Ribble Valley Borough Council
Council Offices
Church Walk,
Clitheroe
Lancashire
BB7 2RA

Phone: 0300 123 6780
Email: developeras@lancashire.gov.uk
Your ref: 3/2025/0895
Our ref: 3/2025/0895/HDC/KW
Date: 23 February 2026

Location: Barn and outbuilding adjacent to Leagram Mill Farm Dinkling Green Lane Chipping PR3 2QS
Proposal: Conversion of existing barn and outbuilding to create a 4 bedroom dwelling with detached dwelling, including alterations to fenestration, insertion of rooflights, insertion of flue and associated landscaping, parking and private amenity space.
Grid Ref: 363862 444145

Figure 2.1 : Proposed Site Layout (source: Zara Moon Architects)

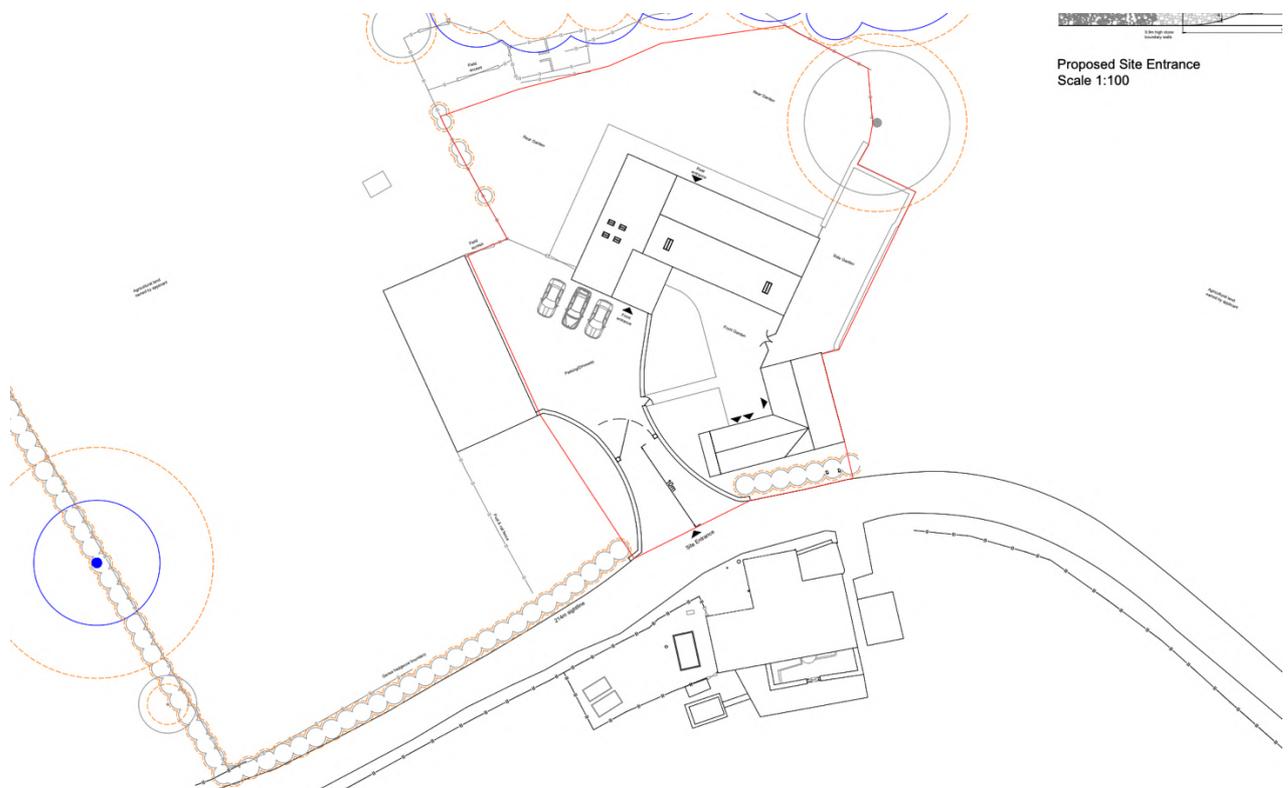
The LHA have reviewed drawing number 07, Revision A, titled Proposed Site Plan and are aware that the dwelling complies with the LHAs parking standards as defined in the Joint Lancashire Structure Plan.

The site shall enhance its sustainable transport options to actively encourage and support sustainable transport use. The development must include covered and secure cycle storage to ensure adequate parking provisions and to promote cycling as a sustainable mode of transport. The LHA note the presence of a cycle and bin store provided adjacent to the outbuilding.

Figure 3.1 : Proposed Site Access Arrangement

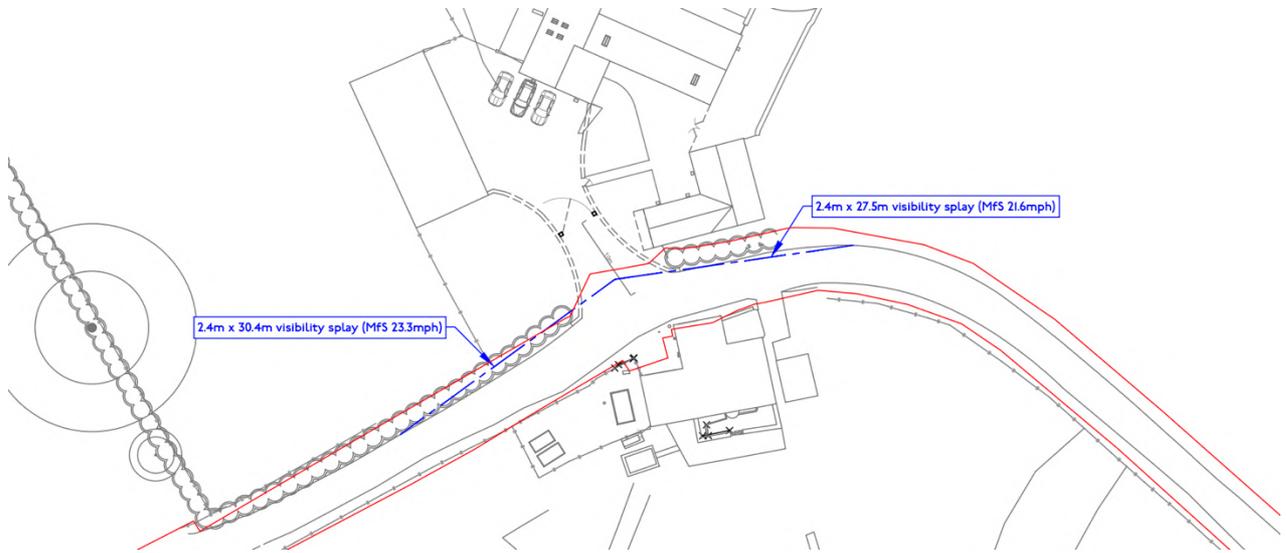
The applicant has provided a traffic survey as detailed within the submitted documentation, reference TN01. The traffic survey was carried out for 7 days by an independent traffic survey company from 19th to 25th January 2026. The ATC recorded two-way 85th percentile speeds in the vicinity of the site access. The results show that the 85th Percentile Speeds Eastbound was 21.6 mph and Westbound was 23.3 mph. As such visibility splays of splays of 2.4m x 27.5m and 2.4m x 30.4m shall be provided.

Drawing J32-9380-PS-001 within document TN01 show achievable visibility to the west and east within land under the control of the applicant and the adopted highway. Nothing shall be erected, retained, planted and / or allowed to grow at or above a height of 0.9 metres above the nearside carriageway level which would obstruct the visibility splay of the proposed access.

There is room to manoeuvre within the site which will allow for ingress and egress in a forward gear as shown within drawing J32-9380-PS-001 in Appendix D of the submitted document TN01.

4. No building shall be occupied until visibility splays 2.4 metres back from the centre line of the access and extending 27.5m Eastbound and 30.4m Westbound on the nearside carriageway edge have been provided at the access, as shown on the approved plans. Nothing shall be erected, retained, planted and / or allowed to grow at or above a height of 0.9 metres above the nearside carriageway level which would obstruct the visibility splay. The visibility splays shall be maintained free of obstruction at all times thereafter for the lifetime of the development.

5. Before the access is used for vehicular purposes, any gateposts erected at the access shall be positioned 10m behind the nearside edge of the highway. The gates shall open away from the highway.
